Referral Point : Claire Potts / Planning Officer – seeking advice on an application for approval of reserved matters relating to tree protection.

Reference : LU/234/16/RES

Location : Land between the A259 Worthing Road and the East Street/Fitzalan Road roundabout

Protection Plan

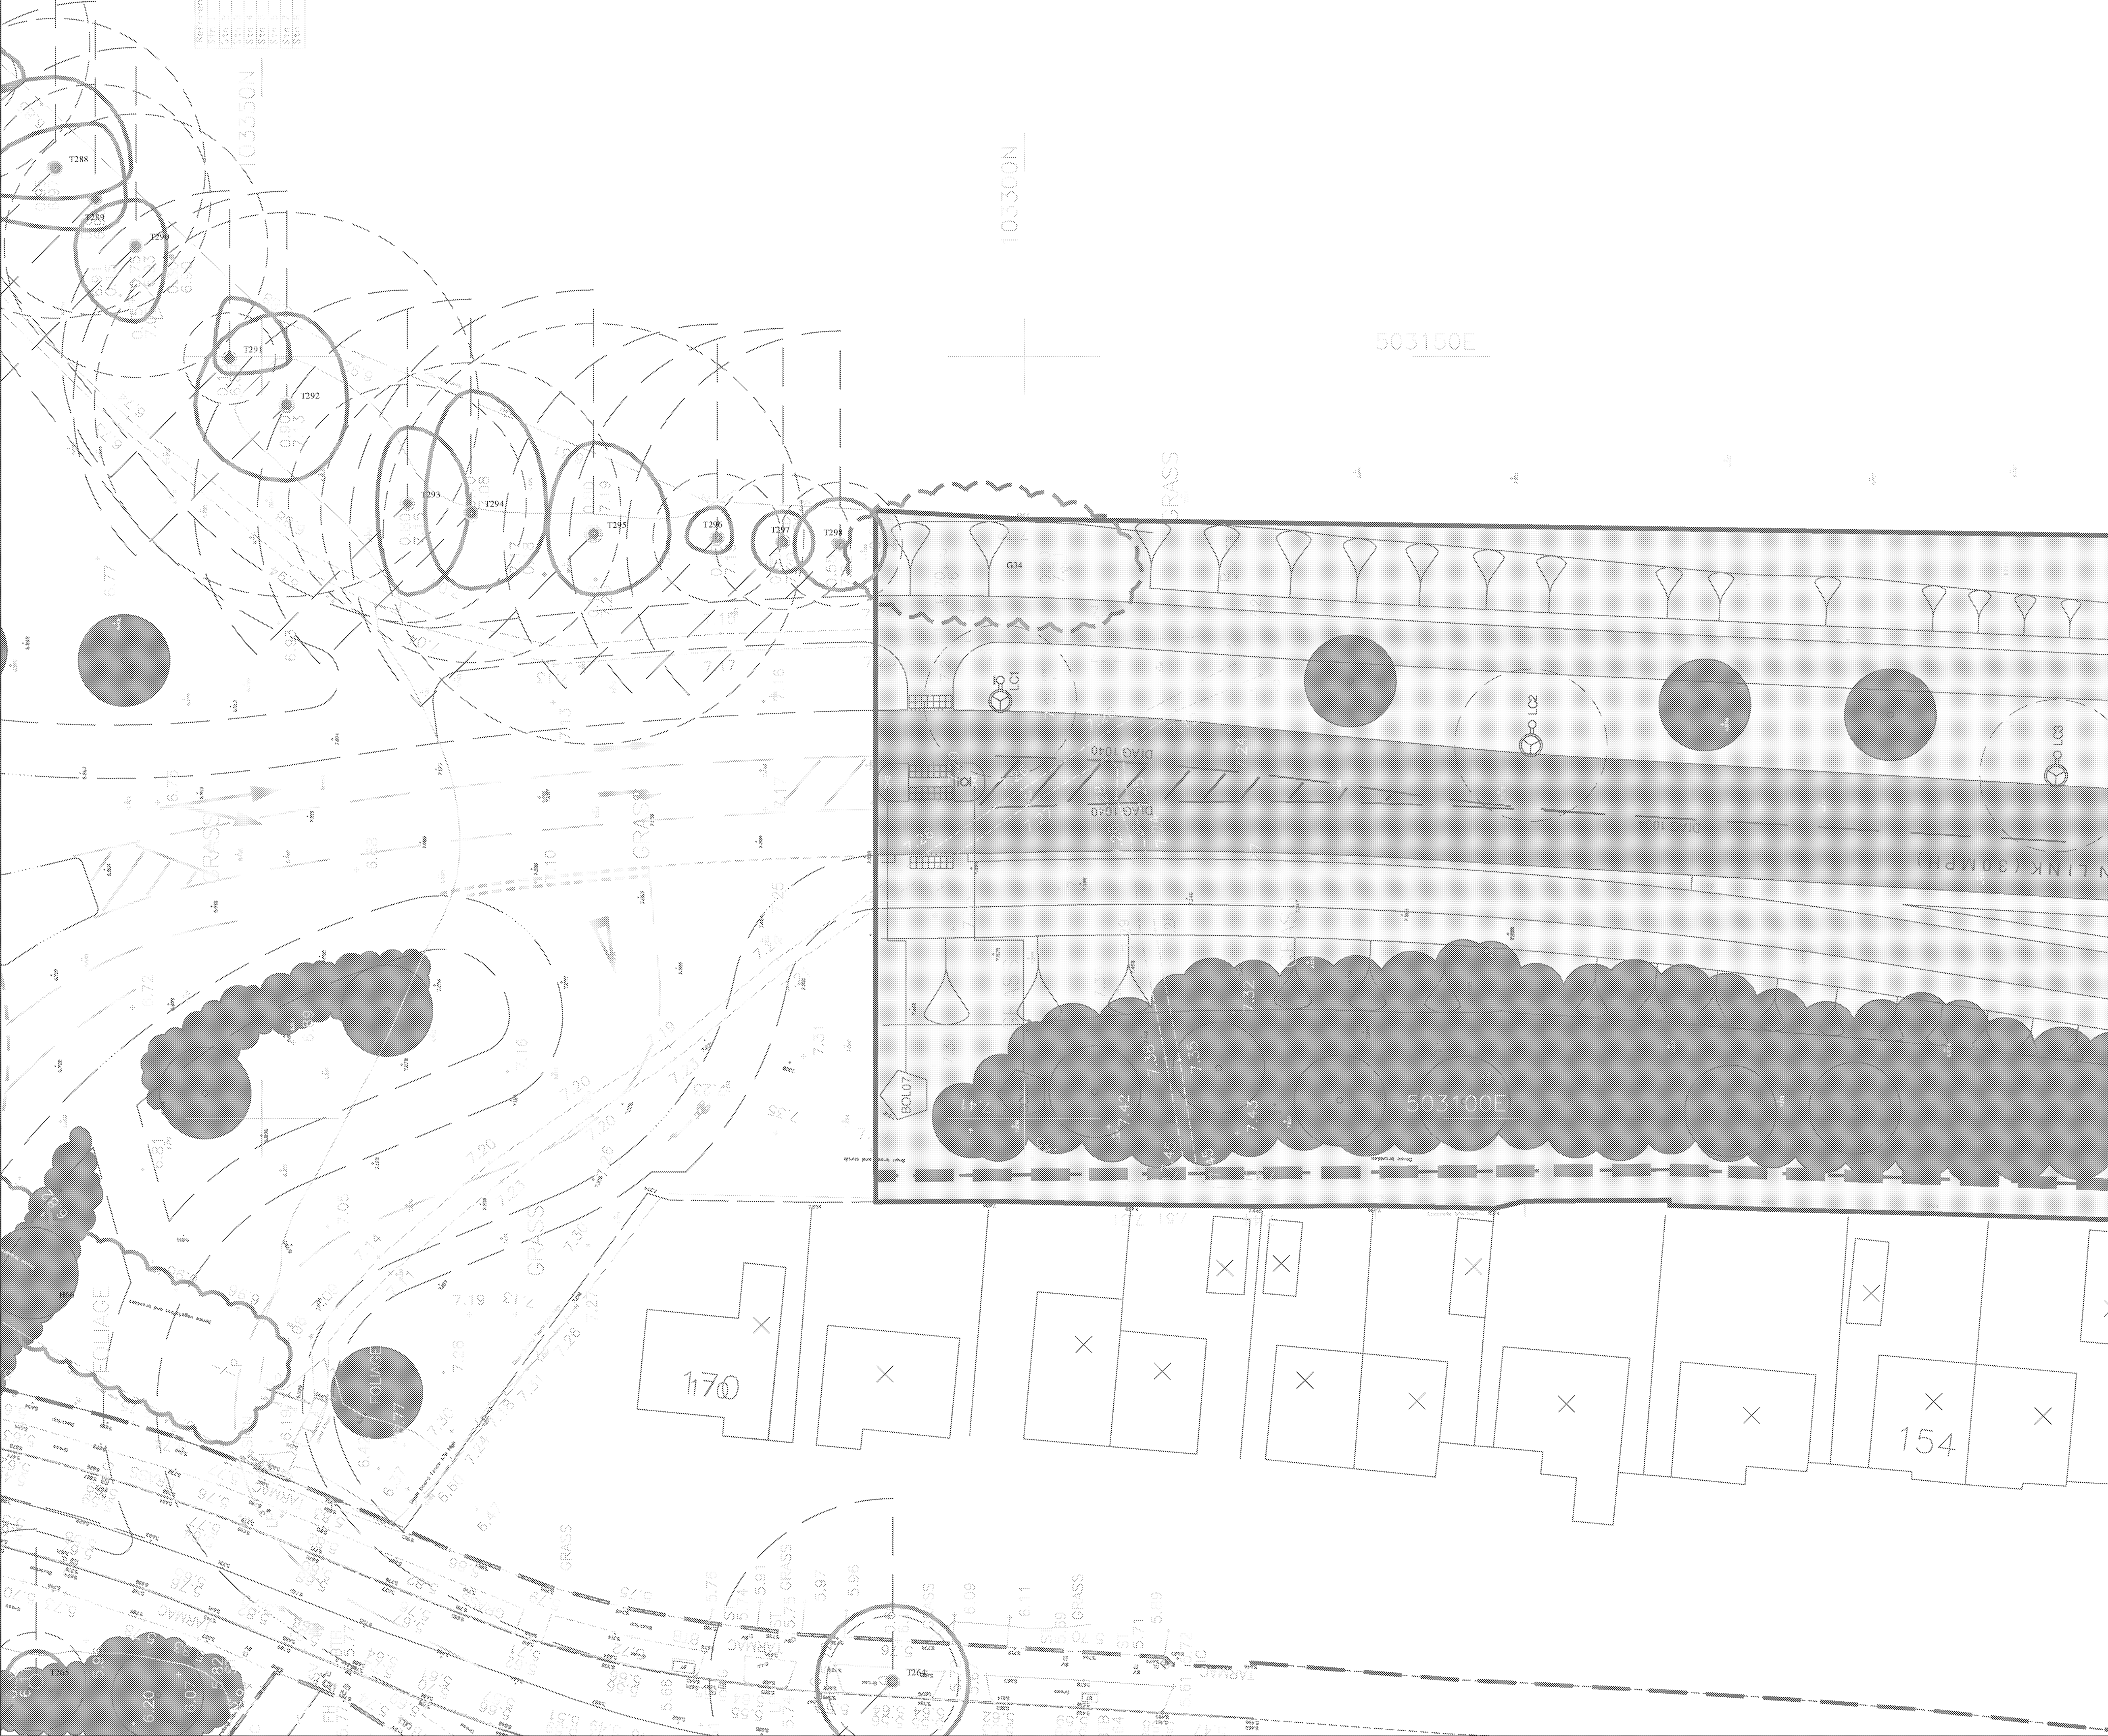
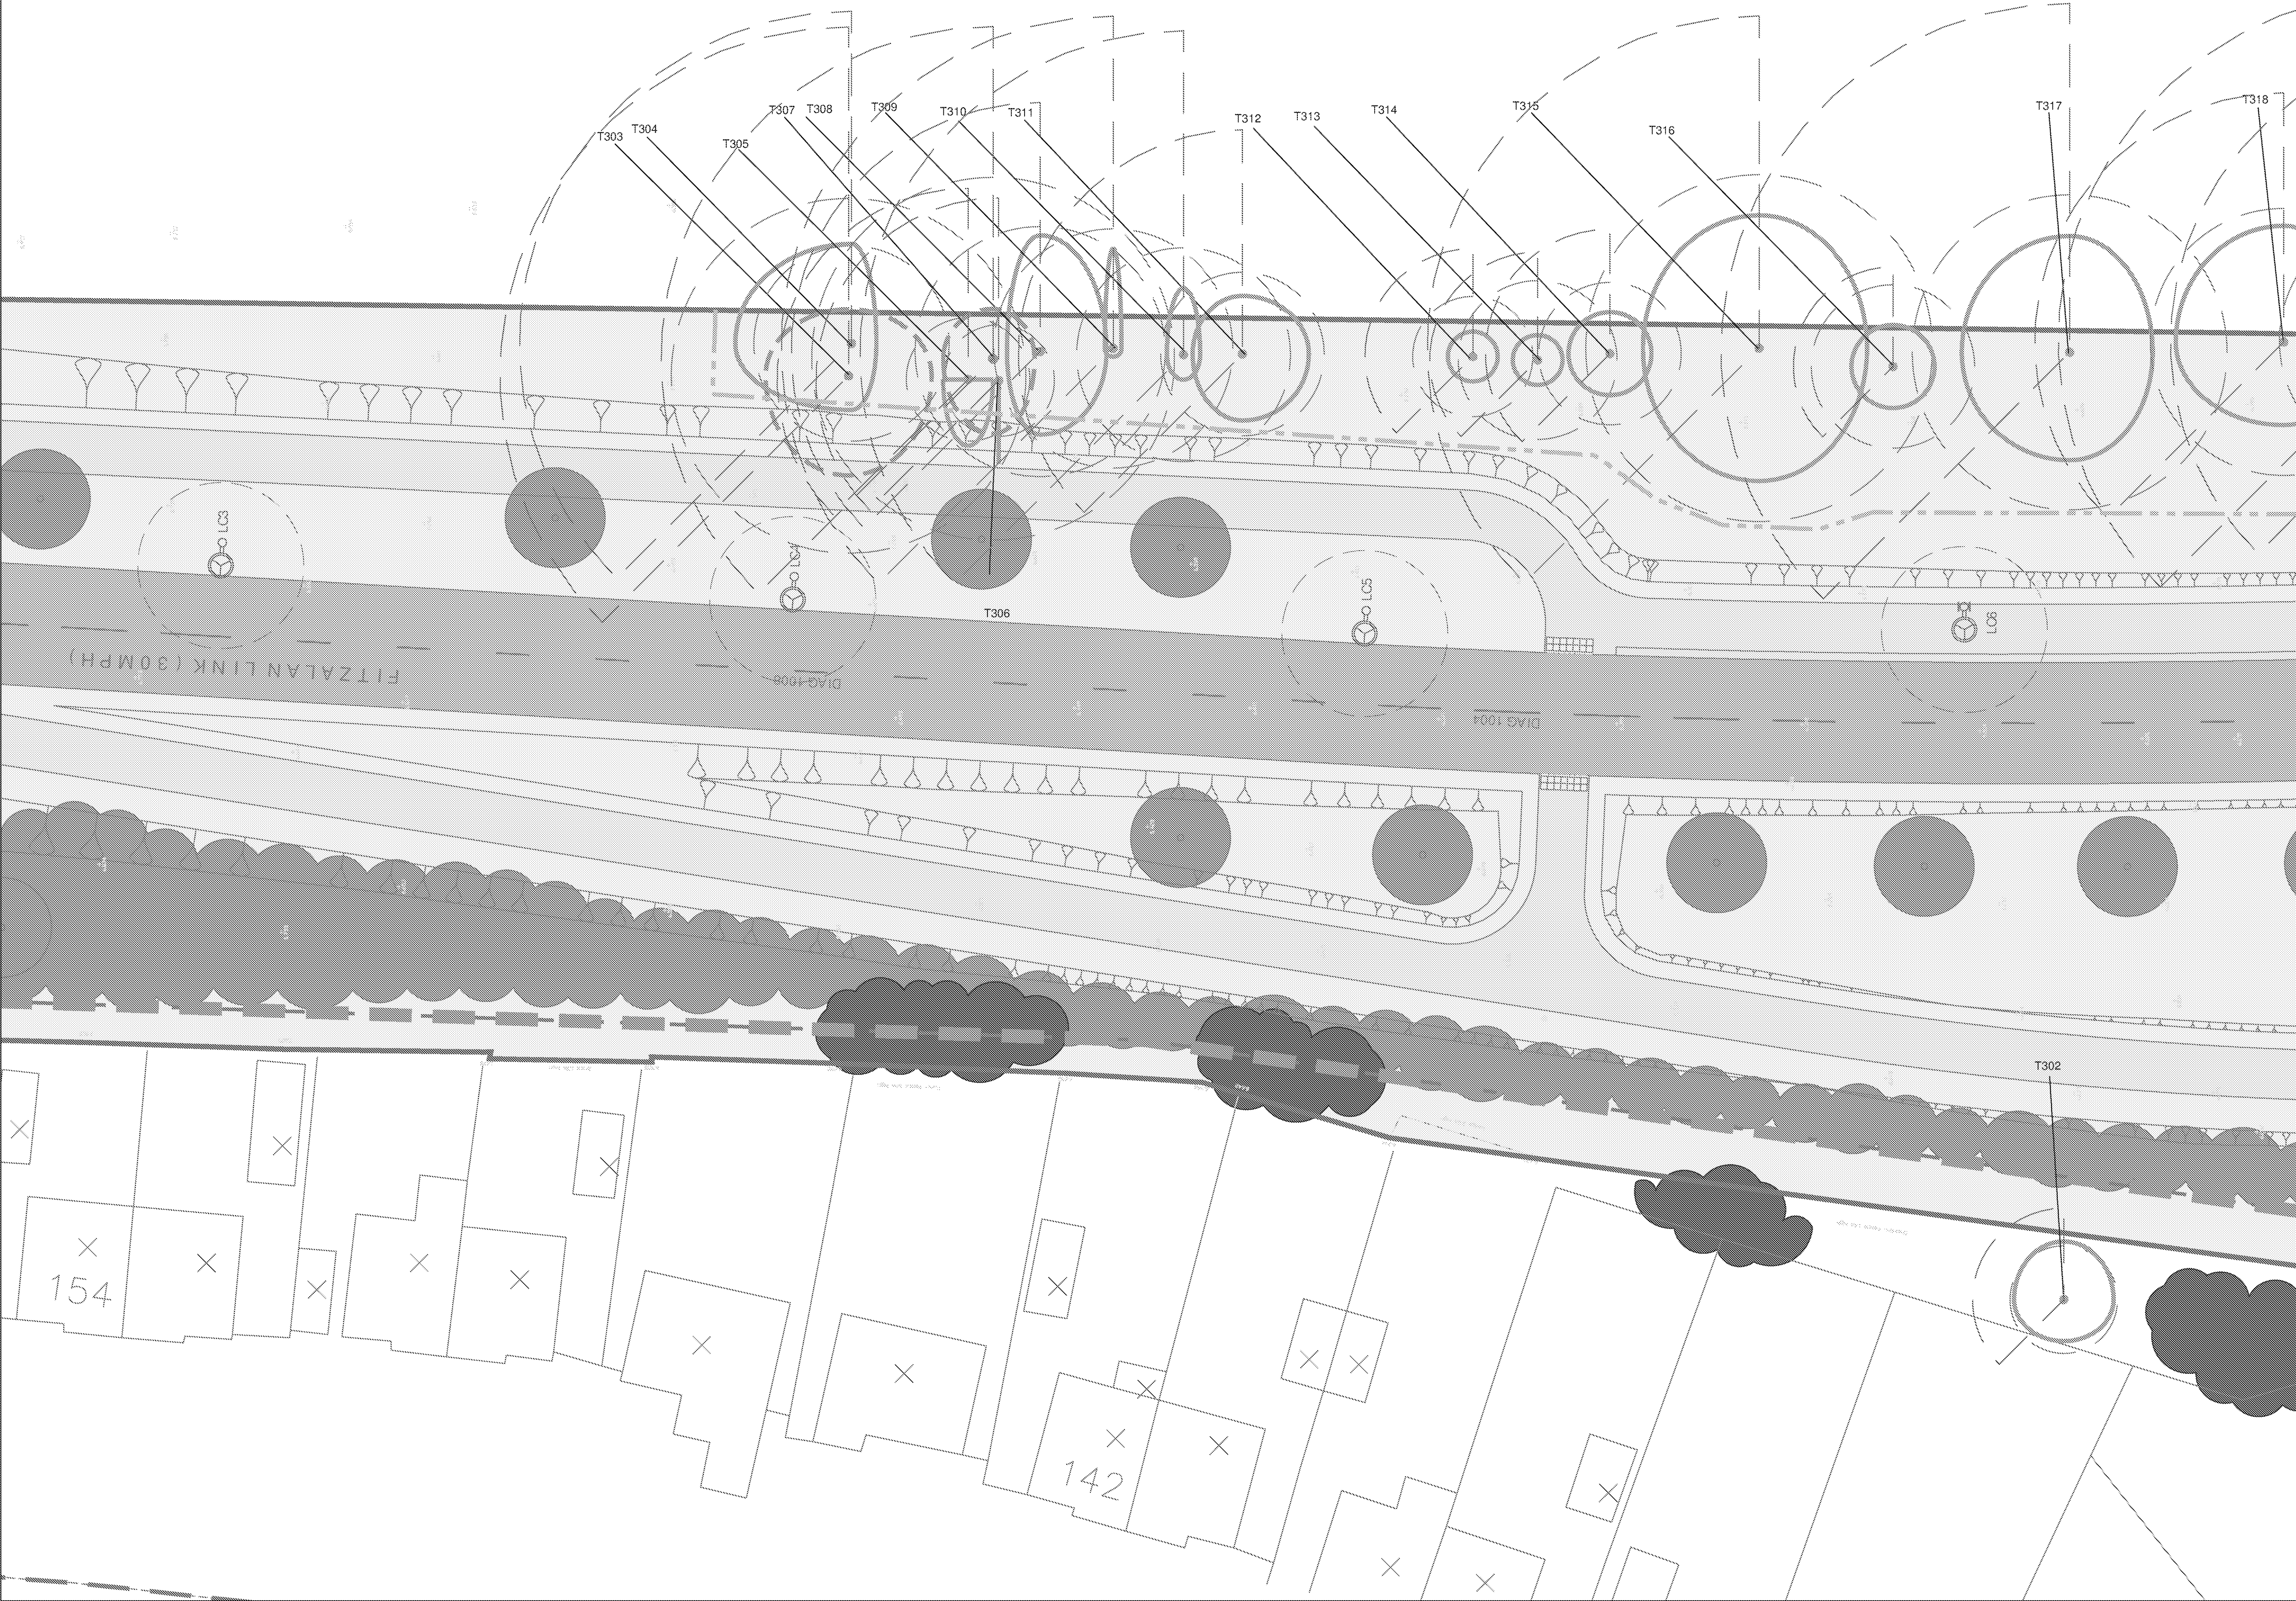
- I walked the route and noted that there are little or no trees or vegetation alongside the western boundary with existing residential development.
- There is however quite a lot of mature and maturing Lombardy Poplars/Hybrid Poplars and Ash trees alongside the eastern boundary with the Academy School grounds which are trees we would wish to see retained and fully protected during the development process.

- These plans show that a full and detailed tree survey and root protection schedule exercise has been undertaken and that protective fencing requirements have been calculated and plotted on the Landscape Plans.

I am happy with the level of Arboricultural input in respect of plans submitted and the levels of tree protection shown will be adequate to ensure that these trees are all retained in a sound and healthy state. Provided that the protective fencing is to Section 6 & Figure 2 standards as prescribed within BS5837:2012.
